Harnett County Government Complex  
307 Cornelius Harnett Boulevard  
Lillington, NC 27546

**RE: Harnett County Land Use application HTE# 07-5-16920**

Based on the criteria set out in Title 15A, Subchapter 18A, of the North Carolina Administrative Code, Rules .1950, the evaluation indicated that the site is **UNSUITABLE** for the addition requested. Therefore, your request for an existing tank is **DENIED**. The site is denied based on the following:

SITE PLAN APPROVAL

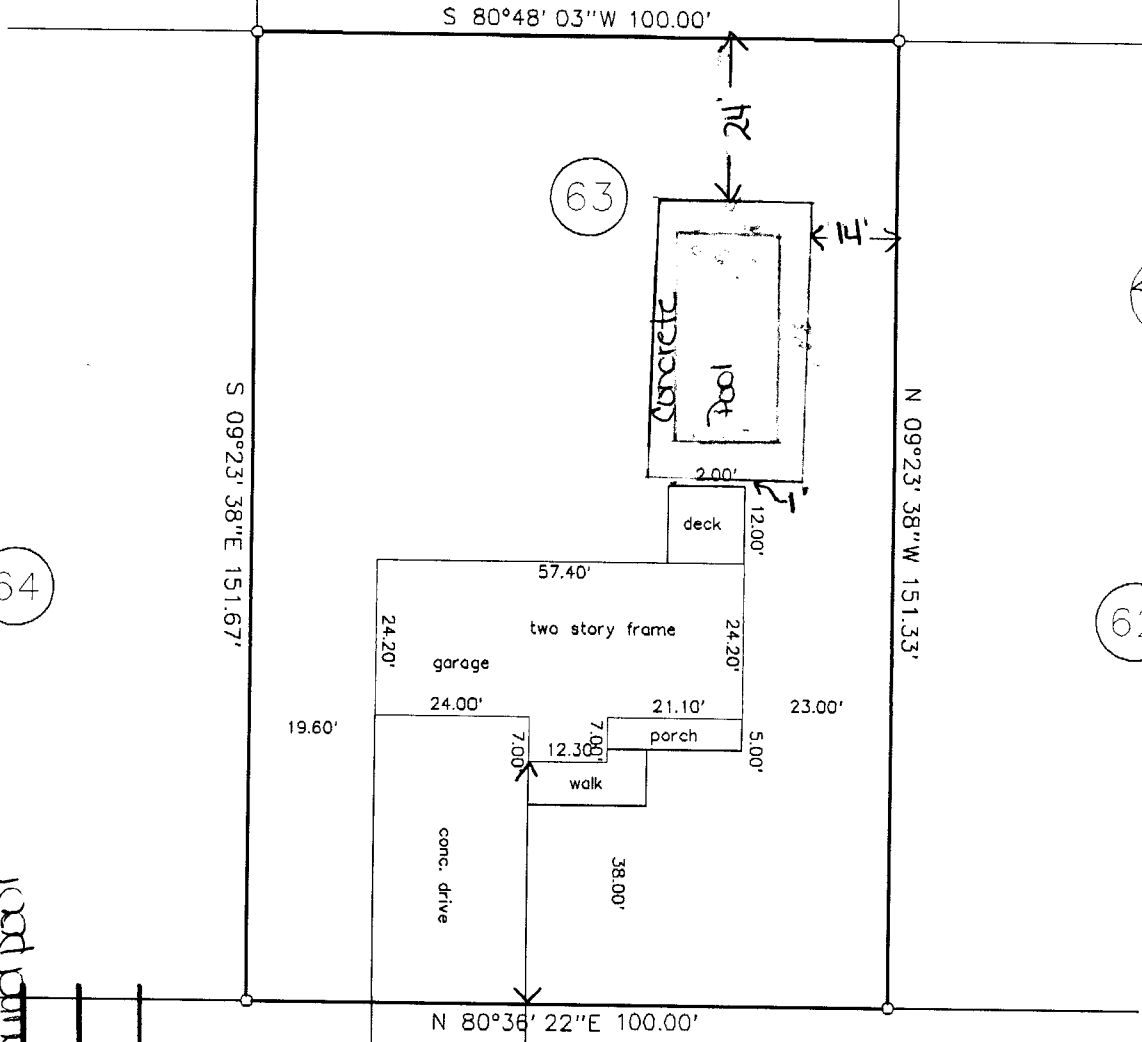
- 15A NCAC 18A.1950 a (16) Any swimming pool must be 15' from any part of septic system.**
- 15A NCAC 18.1945 (b) Each lot shall have original septic system plus repair area.**
- 15A NCAC 18A.1950 (10) – Any building to be 5' from drain line.**

Your options are: *Contact Harnett Co. Public Works about sewer hook-up from Buffalo Lakes Rd*  
OR  
*Contact one of the following Private Consultants and have them design you an alternative repair system for your lot.*
